CITY OF ALBUQUERQUE

August 10, 2015

**Re: Dreamstyle Warehouse Renaissance Center
Erosion Sediment Control Plan
Engineer's Stamp Date 5-19-15 (F16E051A)**

SILT FENCE INLET PROTECTION (IP6)
N.T.S.

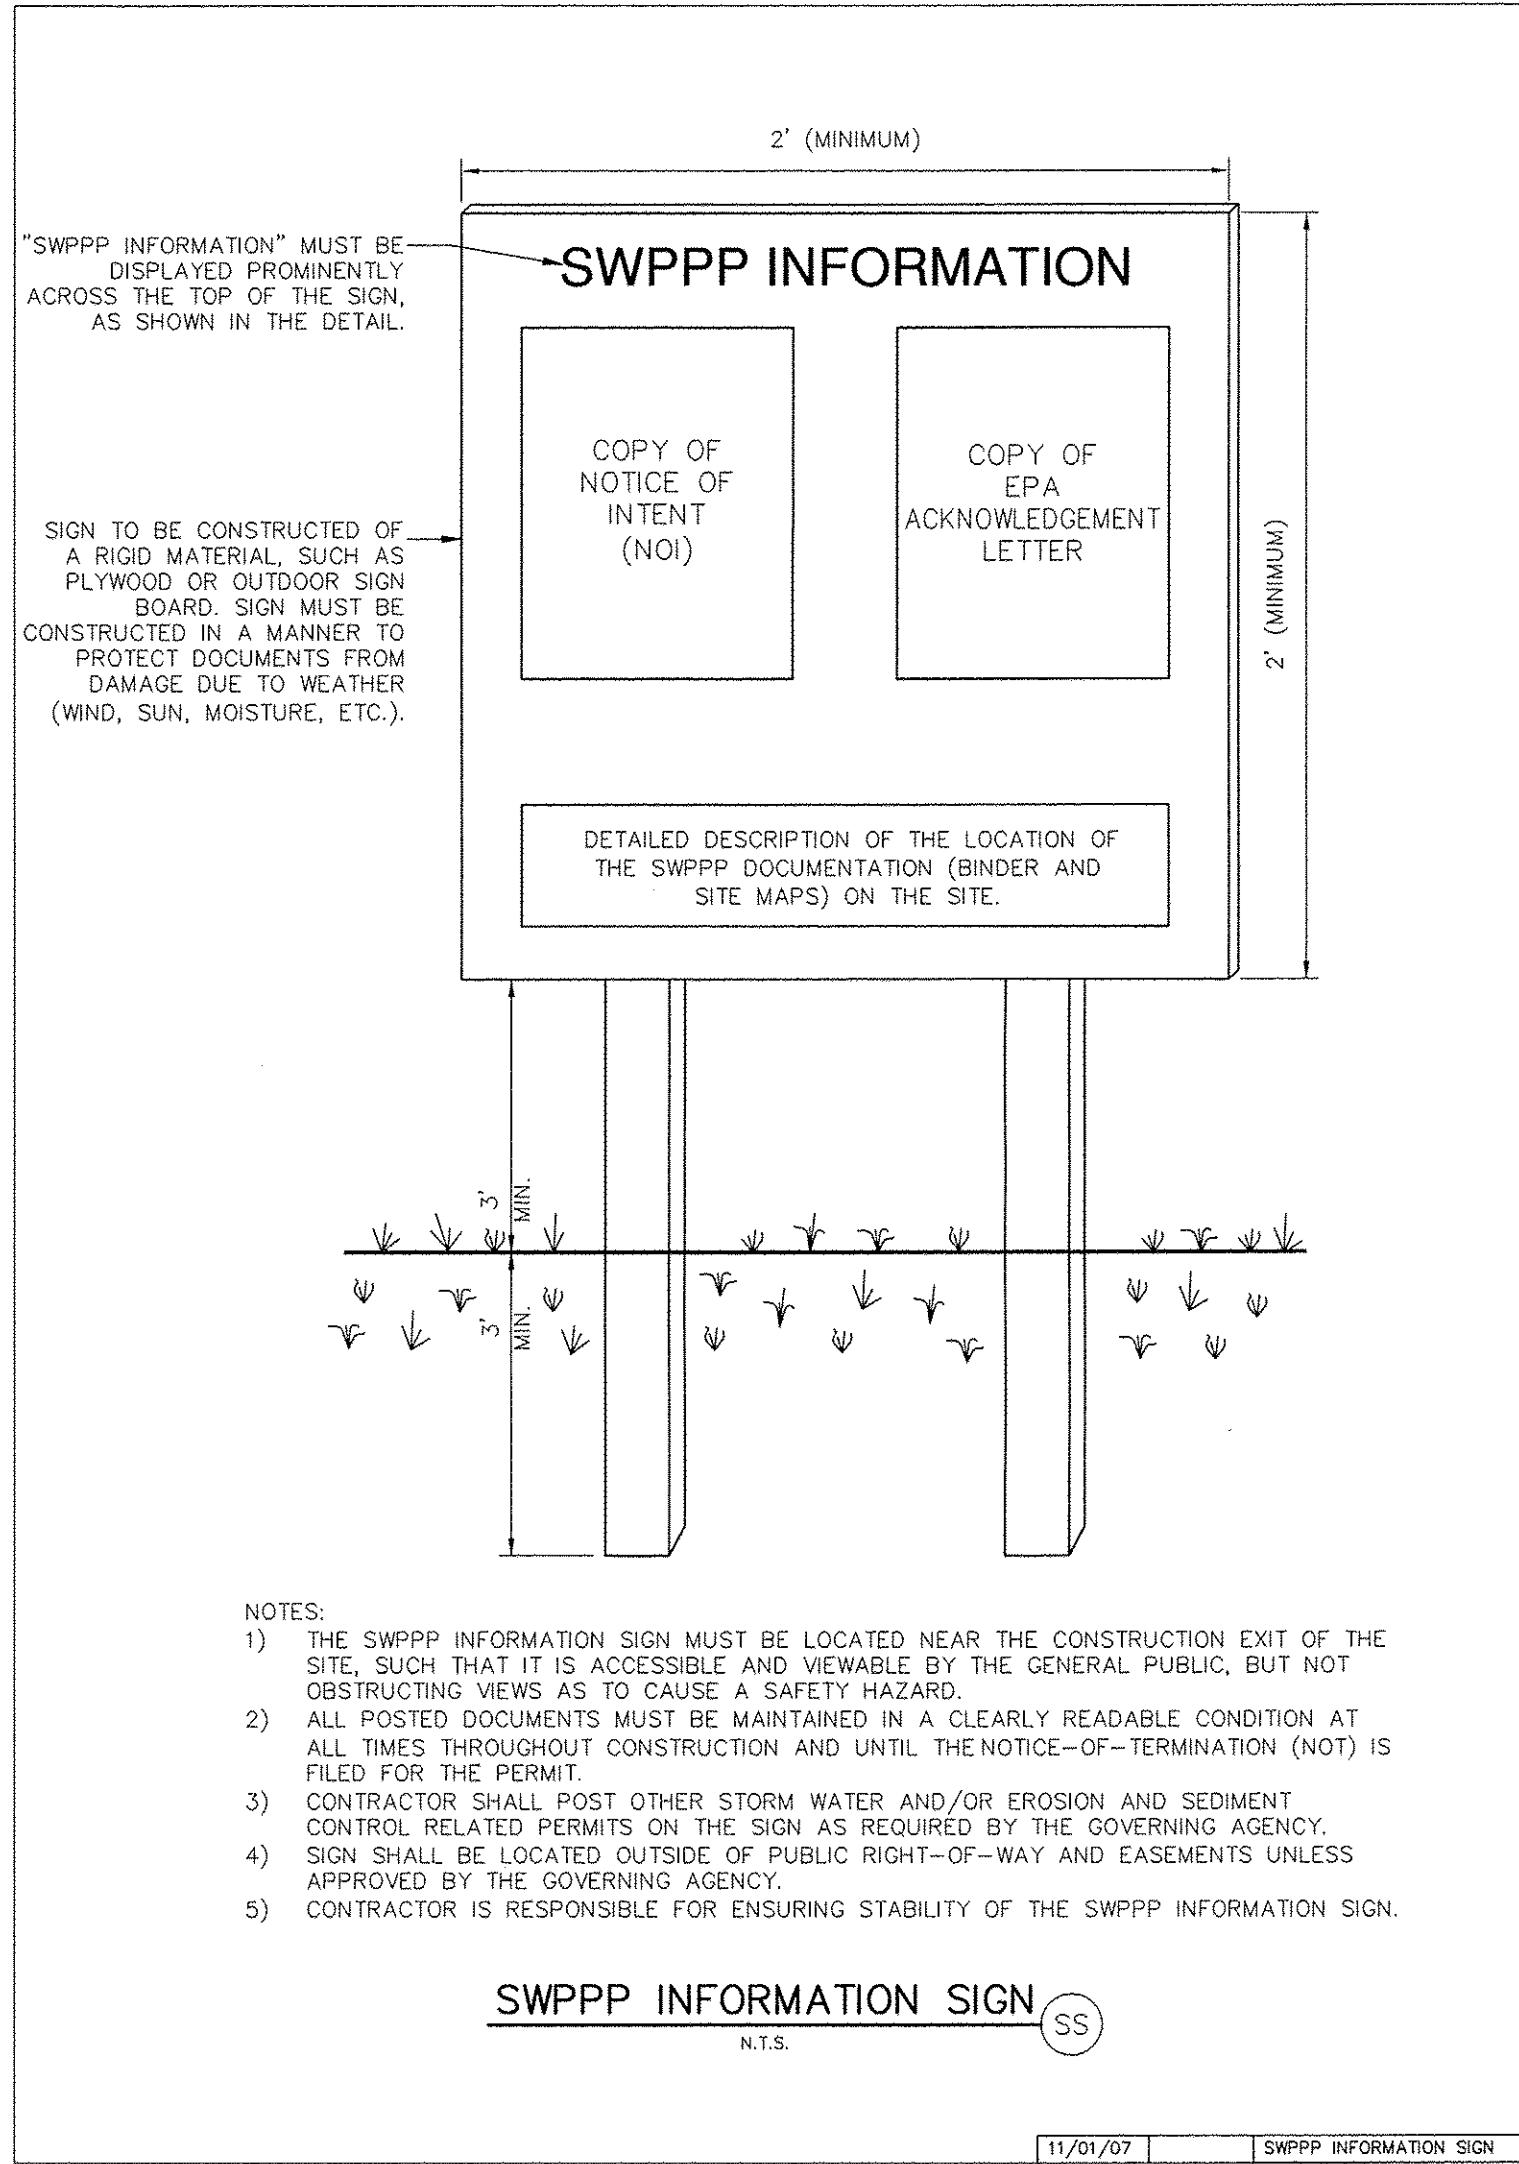
1. Stormwater Quality did not receive a detail sheet with the submittal. Include a detail sheet, similar to other plans you have submitted, in the SWPPP.
